From: Tim Townsend [REDACTED]
Sent: 16 October 2017 10:23
To: Planning.Responses
Cc: Michael Eastham; Claire Potts
Subject: LU/121/17/REM - Landscaping comments

Further to my response to you of 11th October 2017, please find some additional landscaping comments to be read-alongside that report:

Tree planting into Granite Setts on Main Avenue - Plan
Scale 1:50

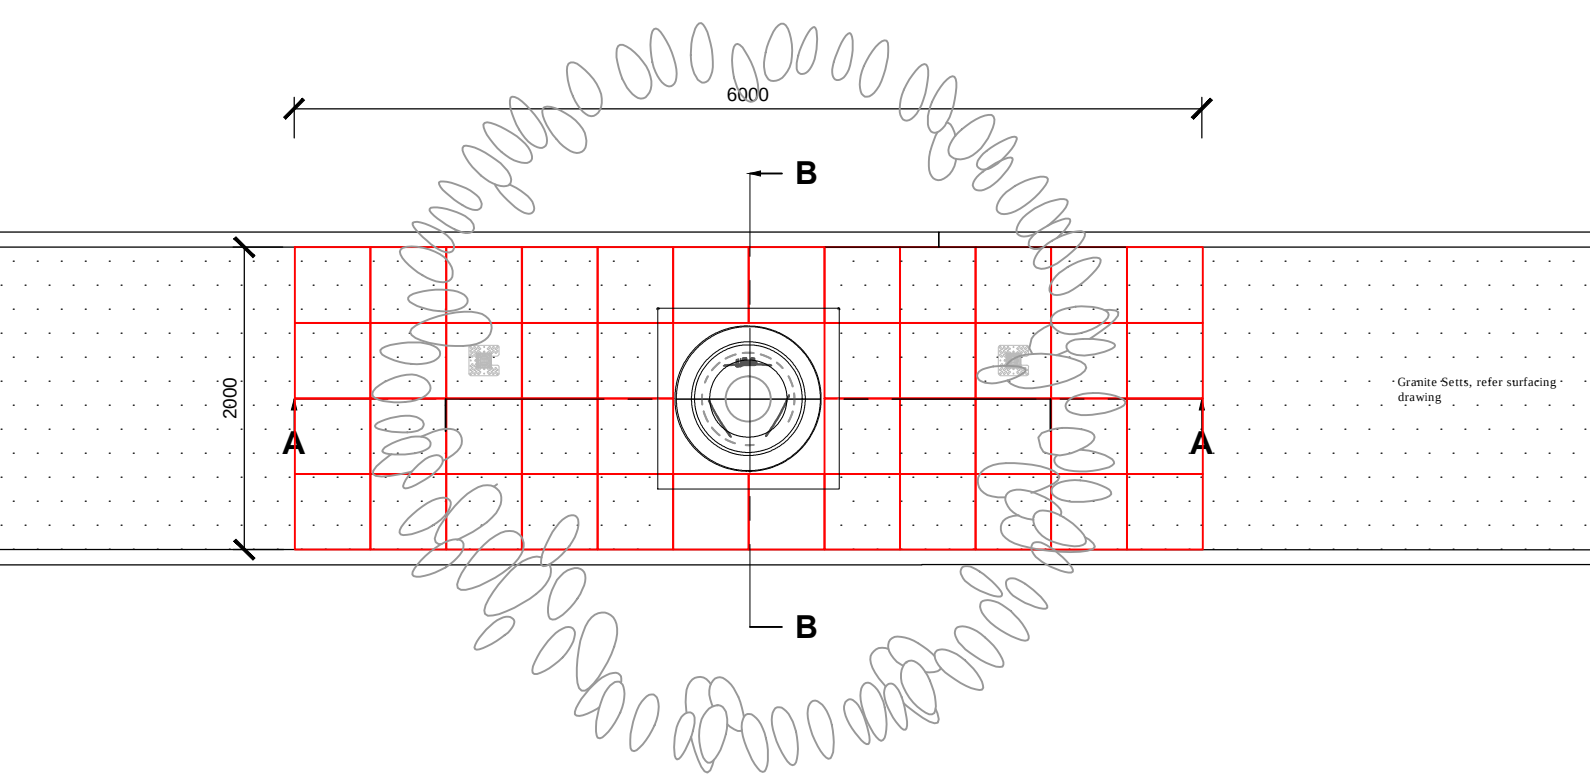
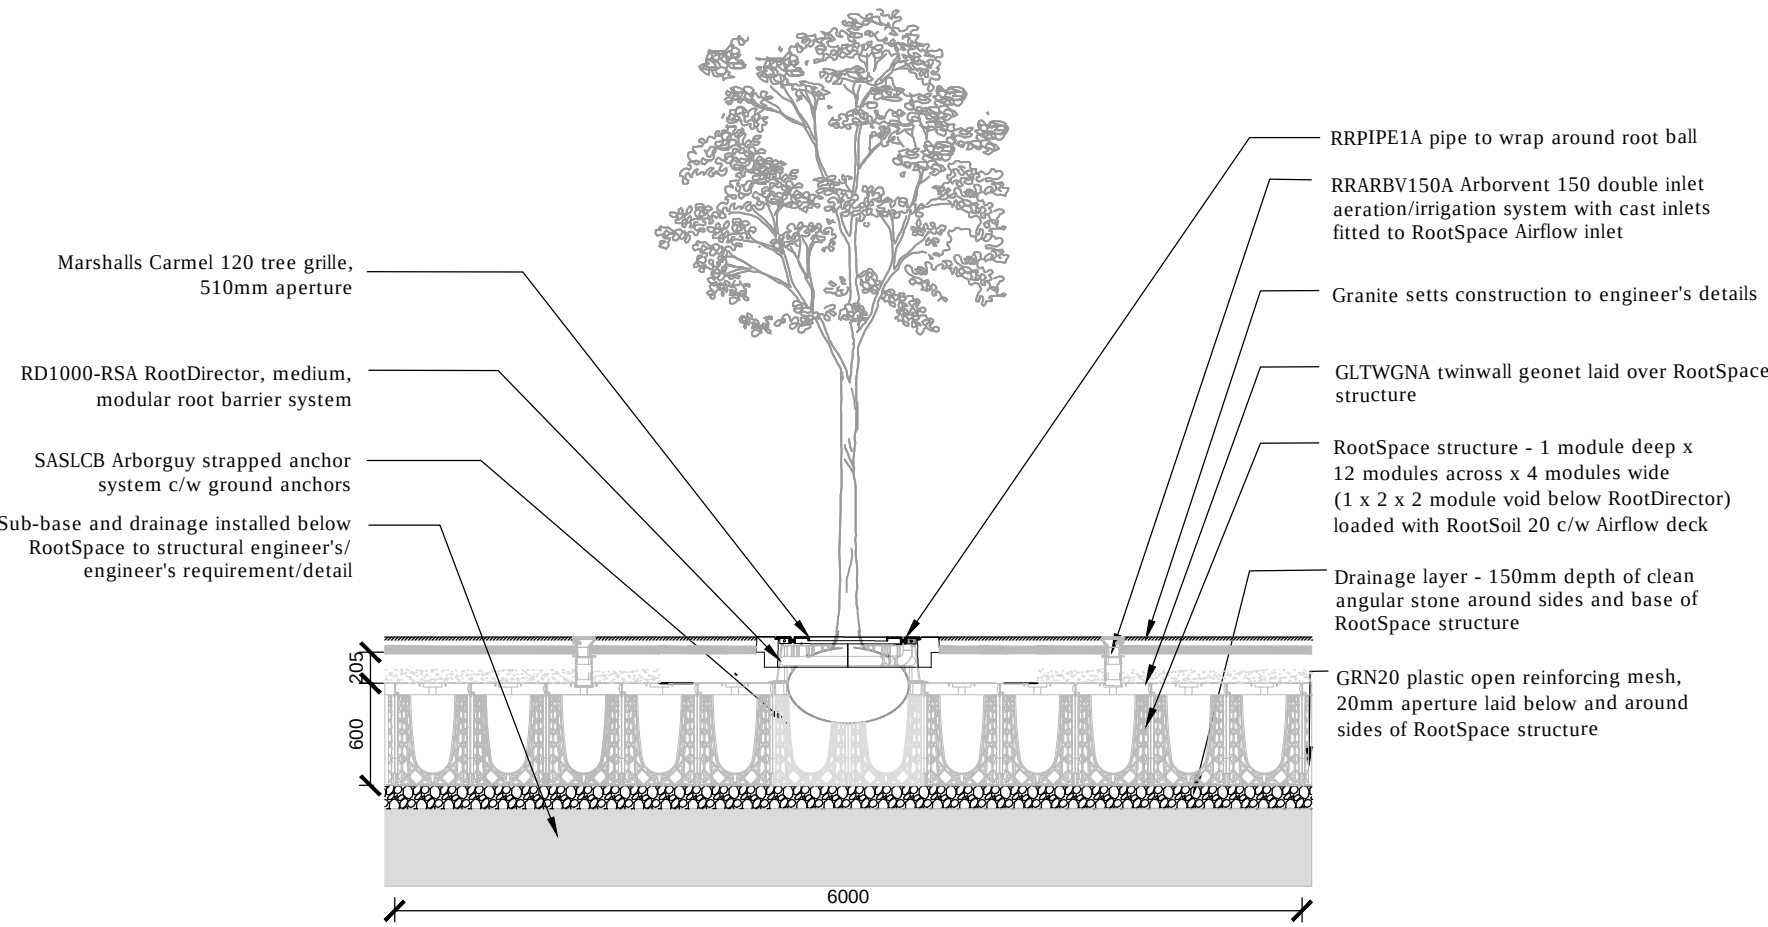
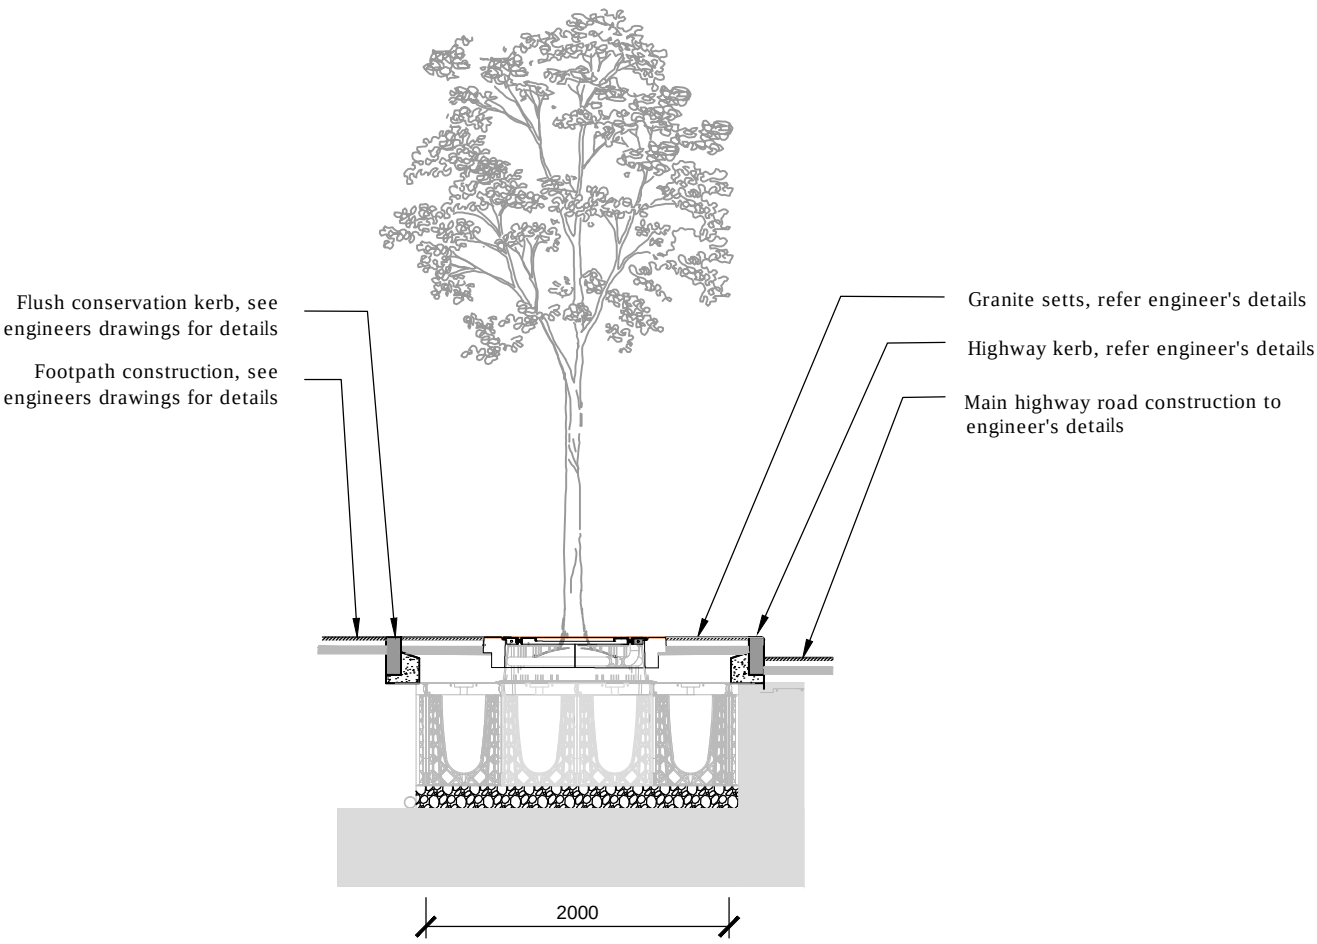
With regard to the first point of the Persimmon response – south of Main Avenue and continuous verge – as the verge is adjacent to a retail/commercial element, a continuous verge would not be appropriate in this location.
